May 2, 2024

**Re: Old Chevron Terminal at 3200 Broadway Blvd SE  
Erosion and Sediment Control Plan  
Engineer's Stamp Date 4/25/24 (M14E038)**

TEMPORARY EROSION AND SEDIMENT CONTROL PLAN

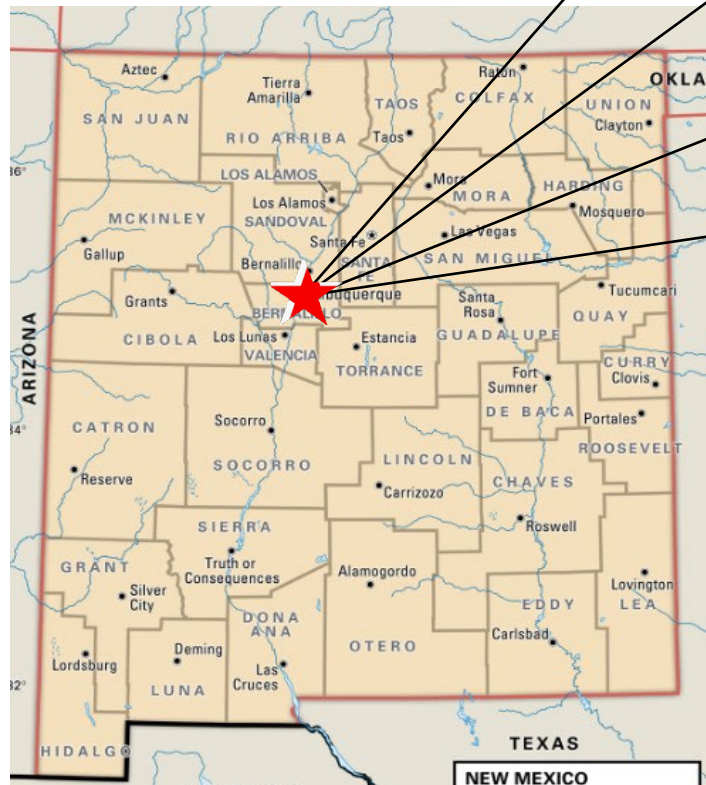
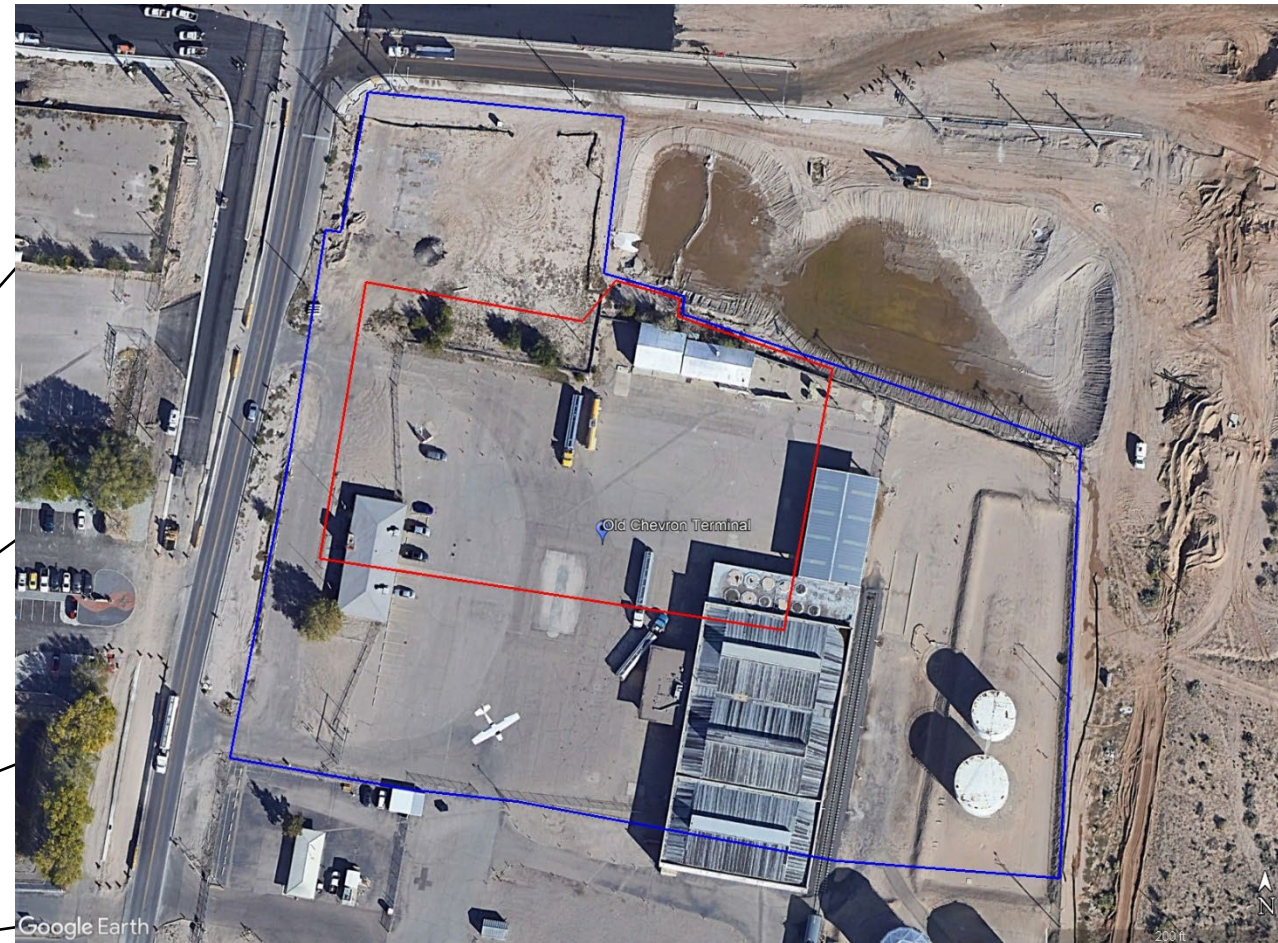
1. The ESC Plan can't be approved until after Hydrology approves the G&D Plan for each specific purpose, Site Plan, Grading, Building Permit, and Work Order. The only purpose Hydrology has approved so far is the Site Plan. The existing and proposed grades must be shown on the ESC Plan, and they must agree with the Grading Plan approved by Hydrology (CGP7.2.4.b.ii).

-  4. The downstream edge of this 7-acre site receives too much drainage for a silt fence alone. The Silt fence should be used in conjunction with berms and sediment basins sized to control the drainage from this 7-acre site per CGP 2.2.12. Sediment Basins must be designed and stamped by a registered Professional Engineer (PE), not a Certified Professional in Erosion and Sediment Control (CPESC). Your BMPs must be sized for the area that drains to them, all of the area, not just the onsite disturbed portion of the drainage area.

- c. Identify controls on the ESC Plan to minimize the exposure of PCB-containing building materials, including paint, caulk, and pre-1980 fluorescent lighting fixtures, to precipitation and stormwater. Separate work areas from non-work areas and construct a containment area so that all dust or debris generated by the work remains within the protected area.

SILT FENCE

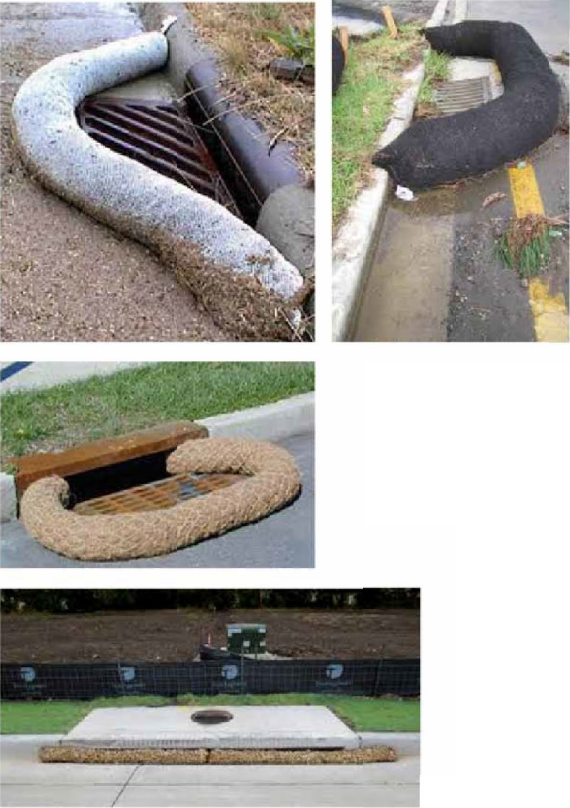
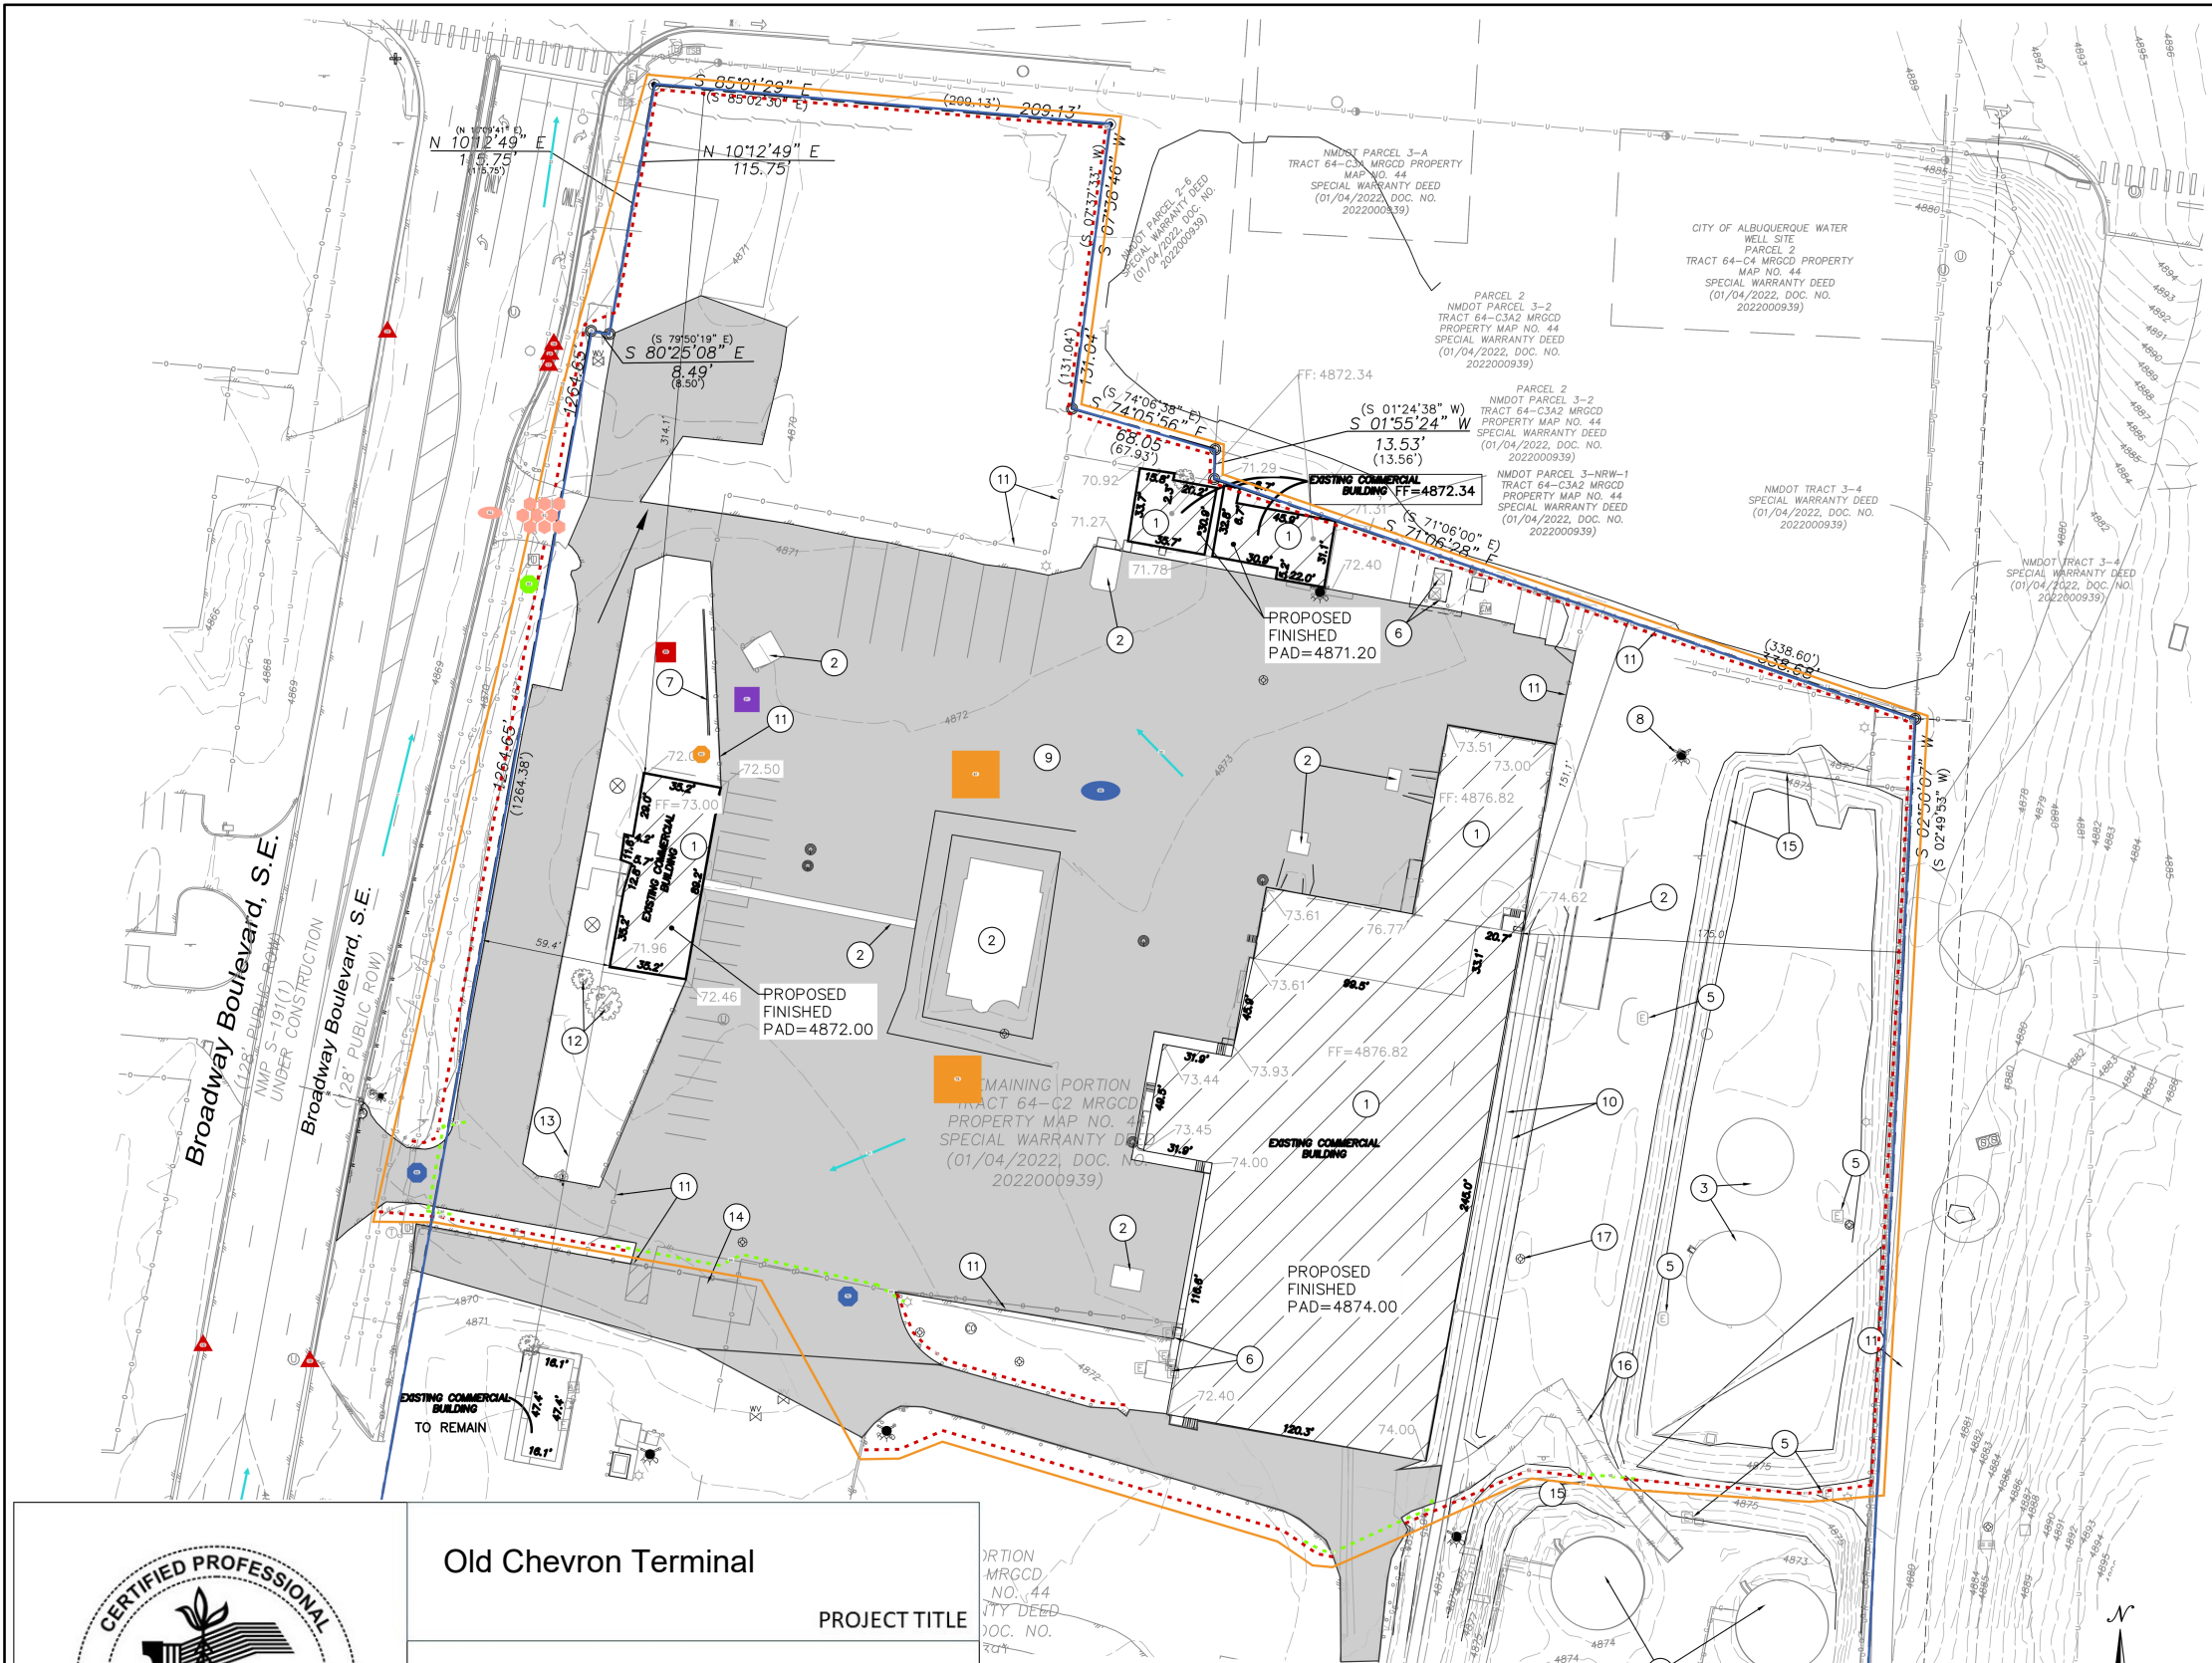
-  5. The SWPPP must describe design specifications, construction specifications, maintenance schedules (including a long-term maintenance plan), inspection criteria, and the expected performance and longevity of the BMPs per CGP 9.6.1.c.i. Specifications for “Weighted Gator Guard” and the other BMPs are missing from the SWPPP. Include all these specifications for the BMPs in the ESC Plan on the detail sheet(s).
